Modification of Development Consent

Development consent:	SSD 10472 granted by the Minister for Planning and Public Spaces on 23 April 2021
For the following:	Expansion of the Museums Discovery Centre (MDC) comprising • removal of vegetation, site preparation and earthworks • demolition of an existing car park area and construction of new car park on the TAFE site • the construction and operation of a new building (Building J) for the storage of the Powerhouse collection and archives, spaces for education and public programs, conservation and research • construction of a new accessway connecting the MDC and TAFE sites • building identification signage, new landscaping, services infrastructure and a roof mounted photovoltaic system • site subdivision and consolidation • implementation of a tree replacement strategy.
Applicant:	Department of Premier and Cabinet
Consent Authority:	Minister for Planning
The Land:	2 Green Road and 172 Showground Road, Castle Hill [Lot 102 DP 11302712 & Lot 1 DP 1066281]

Modification:	SSD 10472 – MOD 2: Amendments to the wording of Condition B13 tree replacement implementation plan and deletion of Condition D3 easement requirements.

PLAN SHOWING PROPOSED SUBDIVISION OF LAND AT CASTLE HILL TAFE COLLEGE, GREEN ROAD, CASTLE HILL, BEING LOT 102 IN DP 1130271 IN THE HILLS SHIRE L.G.A.

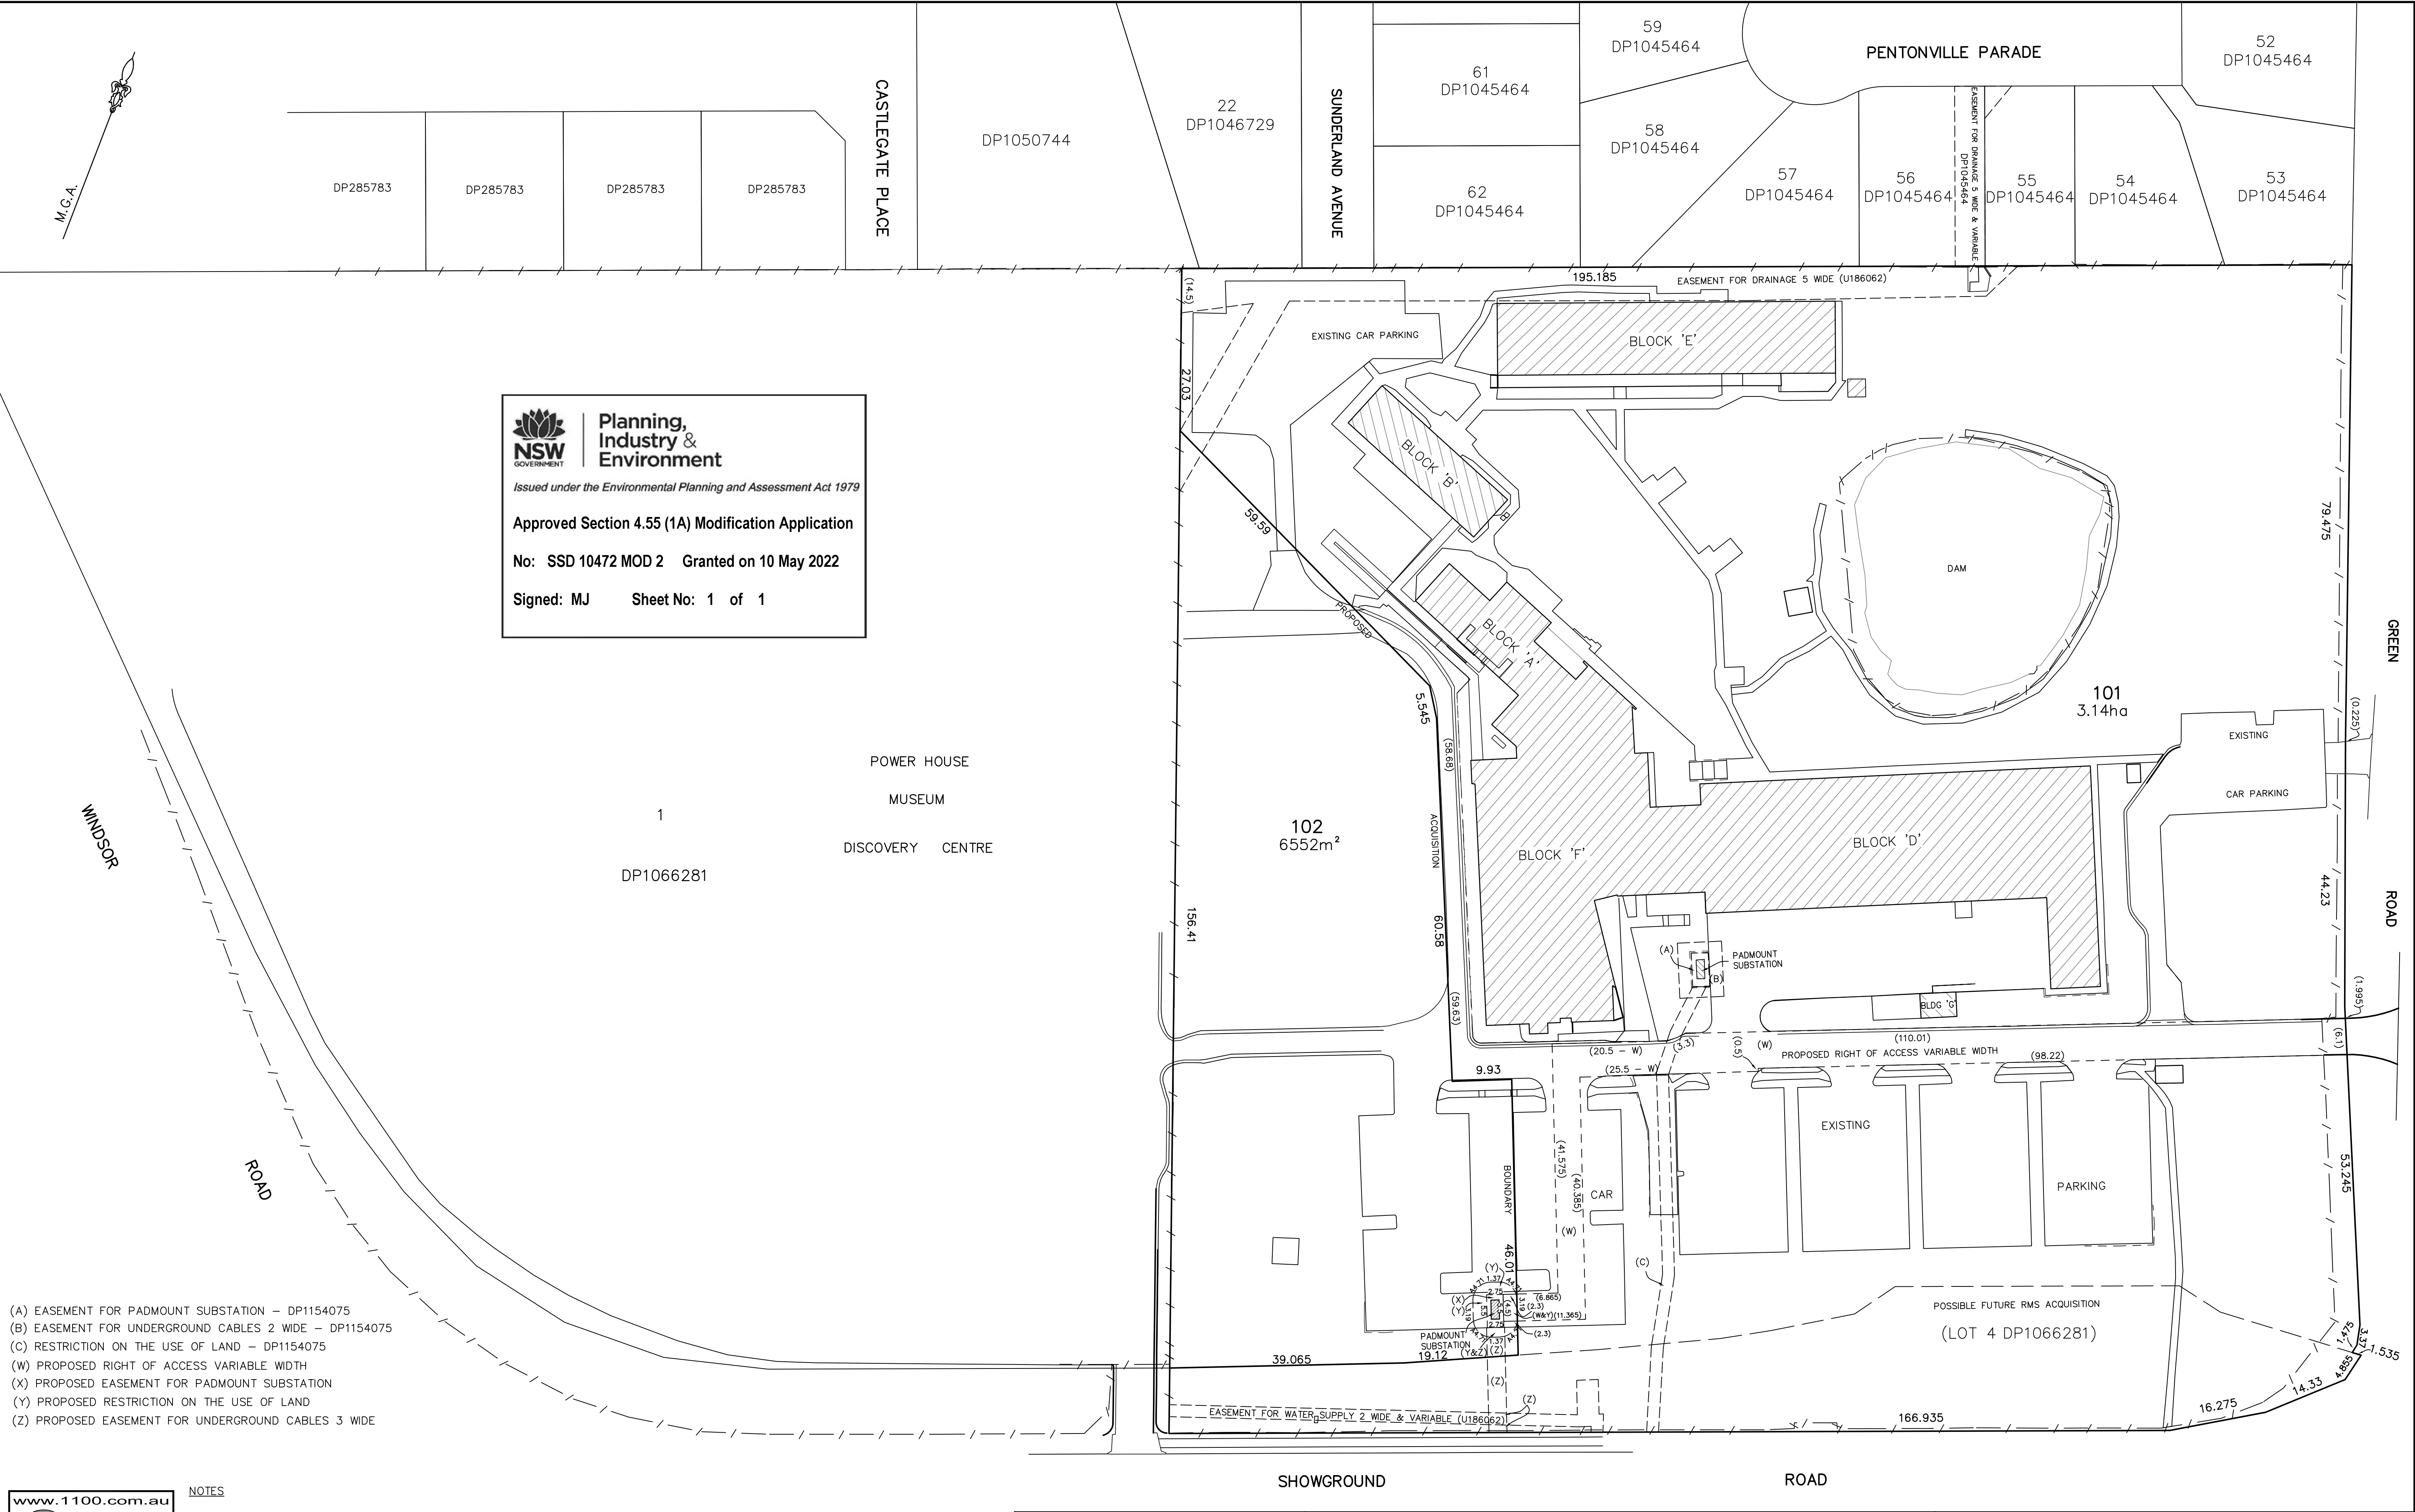
DA1.11	General Arrangement Plan	3	14.01.21
DA2.01	Concept Sediment and Erosion Control Plan	3	14.01.21
DA2.11	Sediment and Erosion Control Details	3	14.01.21
DA2.21	Bulk earthworks	5	14.01.21
DA3.02	Siteworks and Stormwater Management Plan – Sheet 2	4	14.01.21
DA4.01	OSD Details – Sheet 1	3	14.01.21
DA4.02	OSD Details – Sheet 2	3	14.01.21
Subdivision plans prepared by YSCO Geomatics Land Resource Consultants			
<u>08148/15C</u> <u>98148/15D</u>	Plan showing proposed acquisition <u>subdivision</u> of land at Castle Hill TAFE College, Green Road, Castle Hill, being Lot 102 in DP 1130271 in the Hills Shire L.G.A	<u>Proposed</u> <u>substation</u> <u>&</u> <u>associated</u> <u>Easements</u> <u>added</u> <u>Prop.</u> <u>Right of</u> <u>Access</u> <u>Removed</u>	<u>08/9/20</u> <u>4/05/22</u>

~~EASEMENTS~~

- ~~**D3. Prior to issue of a subdivision certificate, an easement under section 88E of the Conveyancing Act 1919 must be registered on proposed Lot 101 benefiting Lot 1 DP 1066281, which provides a right of vehicle access from the MDC site through the TAFE site to Green Road. The easement must name the Council as the prescribed authority, which can only be revoked, varied or modified with the consent of the Council.**~~
